**Memorandum
Planning and Urban Development Department
Planning Division**

Date: June 19, 2014

Re: Fore Street – mixed use building, 185 Fore Street, Bateman Partners, LLC

Project #: 2014-066 CBL: 020 F023

(G) SIDEWALK RAMP DETECTABLE WARNING PANEL
N.T.S.

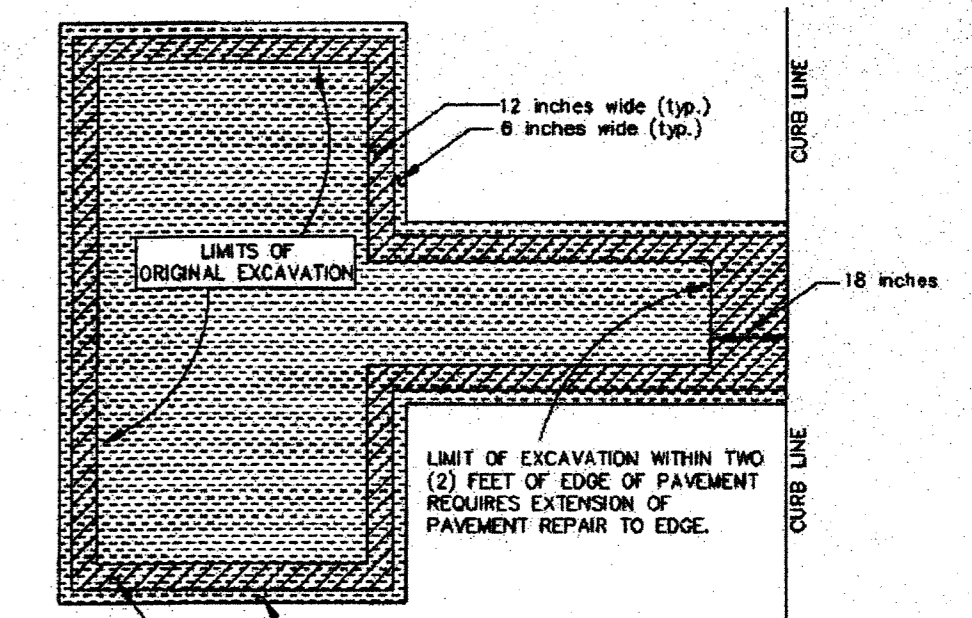
Curb ramps must be designed in detail showing the dimensions of tipdown curbs, flush curb and dimensions of detectable warning panels. Also show the location of any drainage structures and utilities that may impact curb ramp location and design.

(F) BARRIER FREE RAMP DETAILS
N.T.S.

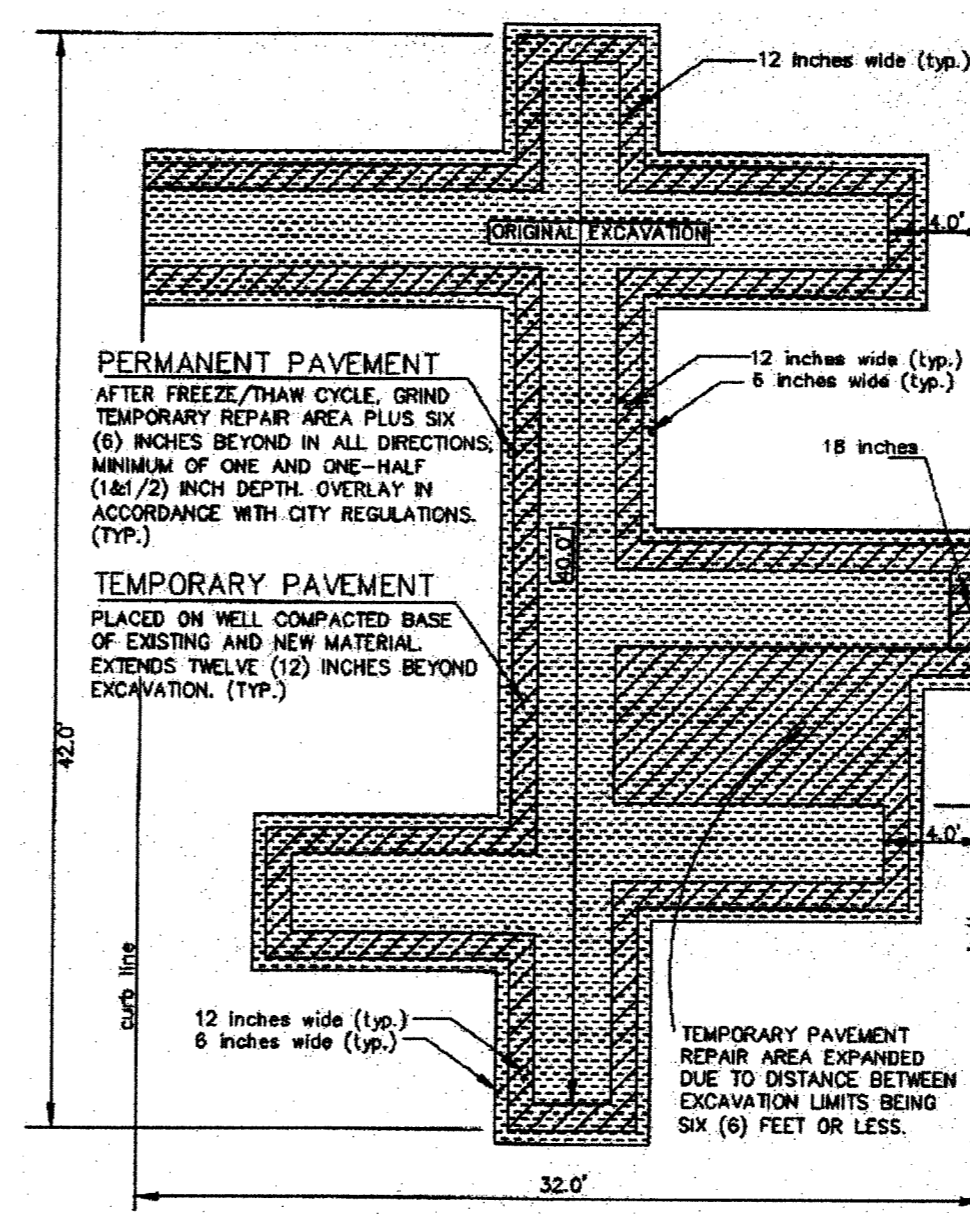
As noted in a recent staff meeting, detailed drawings are required of the ramp proposed to direct pedestrians across Fore Street in particular, as it appears there is insufficient space for a landing that will meet city specifications.
